Project Title: MCT Frontage Road Property Building Permit #: _____ City Drainage #: EMD060

RE: **MCT Frontage Road Property**
Grading and Drainage Plan
Engineer's Stamp Date 7-21-16 (File:E17D060)

Re: MCT Frontage Road Property
Revised Engineers stamp date 7-26-2016- (EI7D060)

From: Carrillo, Abiel X.
Sent: Friday, July 22, 2016 11:33 AM
To: 'Kelly Klein'
Subject: MCT - E17D060 - Stamp Date 6-30-2016

GRADING & DRAINAGE PLAN

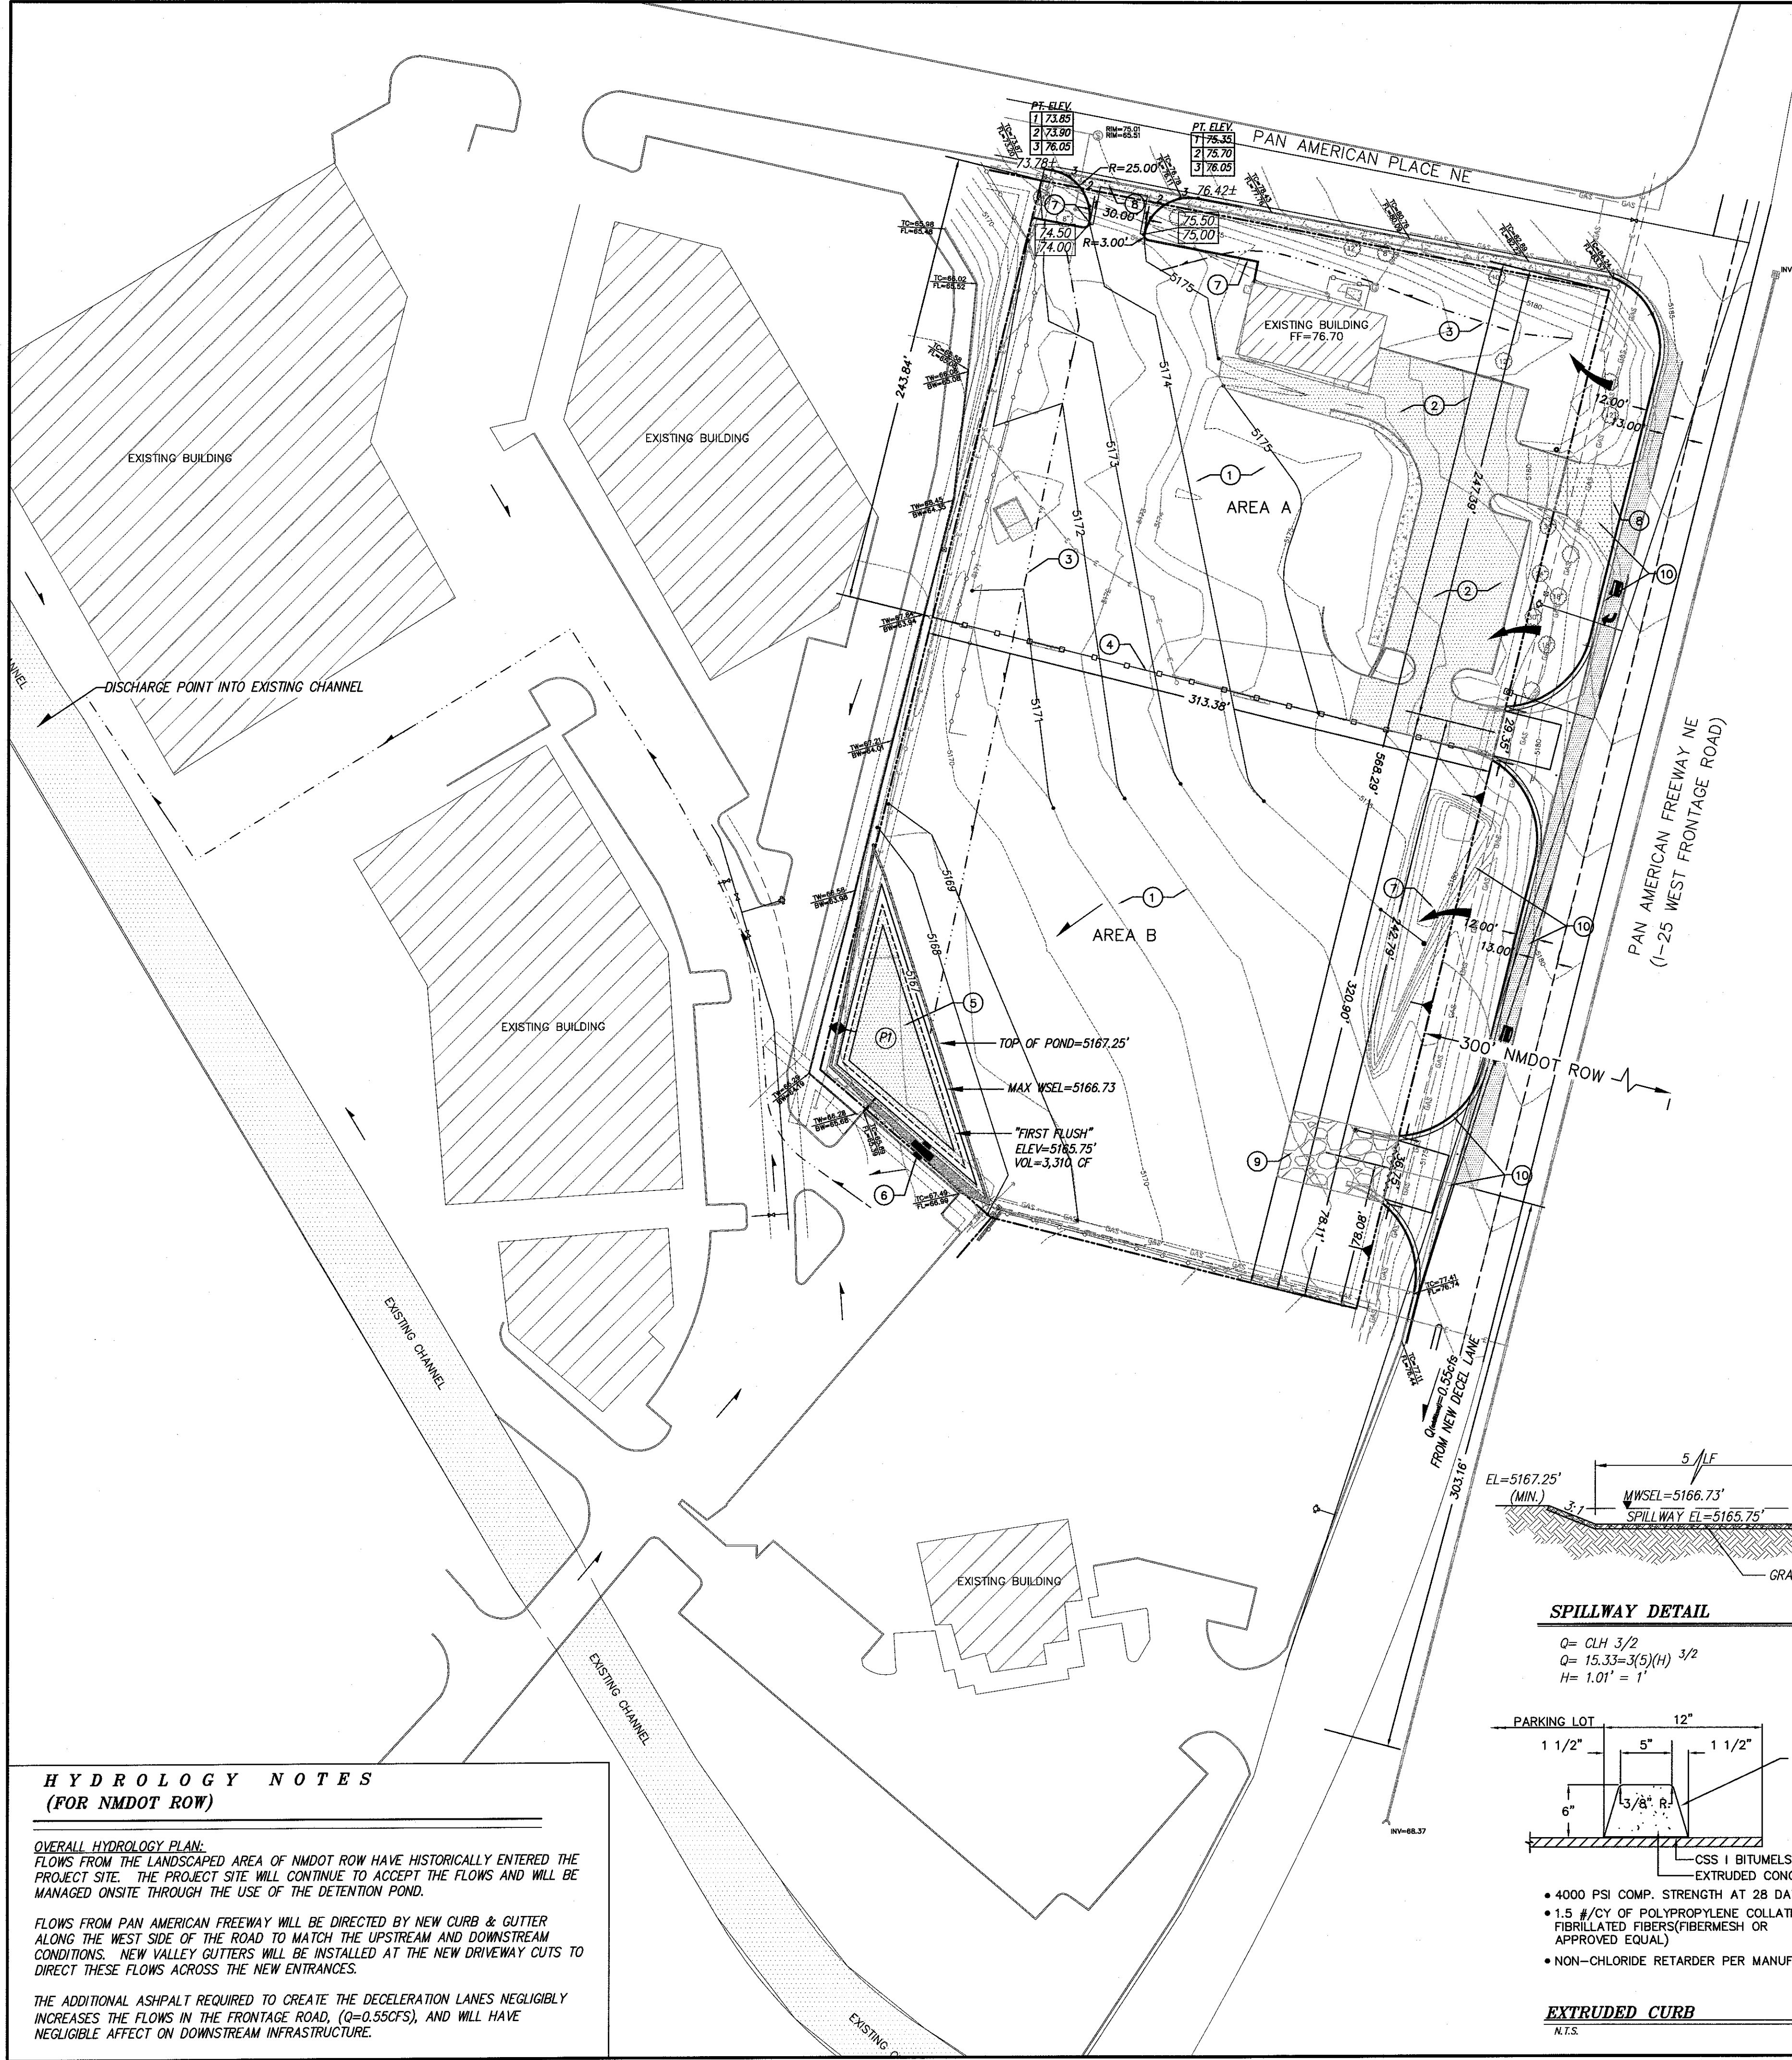
1. The plan proposes to discharge into the adjacent property to the Southwest. It does appear that the general pattern follows the historical path. However, to maintain that historical discharge in the absence of a drainage easement, the exact historical peak flow and location must be maintained; even small increments make the condition no longer historical. Normally, the historical volume would also need to be unchanged, however, the runoff bypasses the adjacent site and enters the channel. A solution can be to retain a little more than half of the volume of the 100-year 24-hour storm, just enough to get to the point on the hydrograph that matches the existing peak flow. When the lot develops further, an easement can be sought, or a detention facility would need to be planned.

- a. I would also check your assumptions for the proposed condition. The %D area goes from 12% existing to 55%. The site appears to have been graded in the existing condition, and it seems like you will need to remove some pavement (based on aerial photos), so it's not clear why the %D increases so much. Are you sure you are actually increasing the runoff?

4. The lots are listed as "lot A" and "lot B", be aware that a cross-lot drainage easement (and possibly an easement over the pond) will be needed for DRB action if the property will be subdivided.

1. **The plan proposes to discharge into the adjacent property to the southwest....."**
In absence of a full drainage report for the adjacent property, we looked at existing and historical conditions. I attached aerial photographs to this letter to show the property from 1996 and 1999. These photographs were taken from Google Earth and the RGIS ortho photography. From these photographs, it is determined that the drainage paths for the area are consistent with the assumptions on the projects site's drainage plan. In addition, there are "offsite" flows from the NMDOT ROW on the east boundary that enter the site. To calculate the historic flows, I inserted the pictures into AutoCAD to get area calculations for the different land treatment types and used AHYMO to determine the flows. The historic flows are summarized on the revised plan and include the offsite flows from the NMDOT ROW.

- a. **"Check the assumptions for the Proposed Conditions..."** The higher assumed impervious area for the proposed conditions is reflective of the use for Area "B". This area will store mini storage sheds on the property that will be for sale to the public. It is assumed that at the highest inventory level, Area B will be 80% impervious.

4. **"...Lot A and Lot B..."** These areas have been renamed to Area A and Area B for clarification. The site is one (1) property and will not require a cross-lot drainage easement.
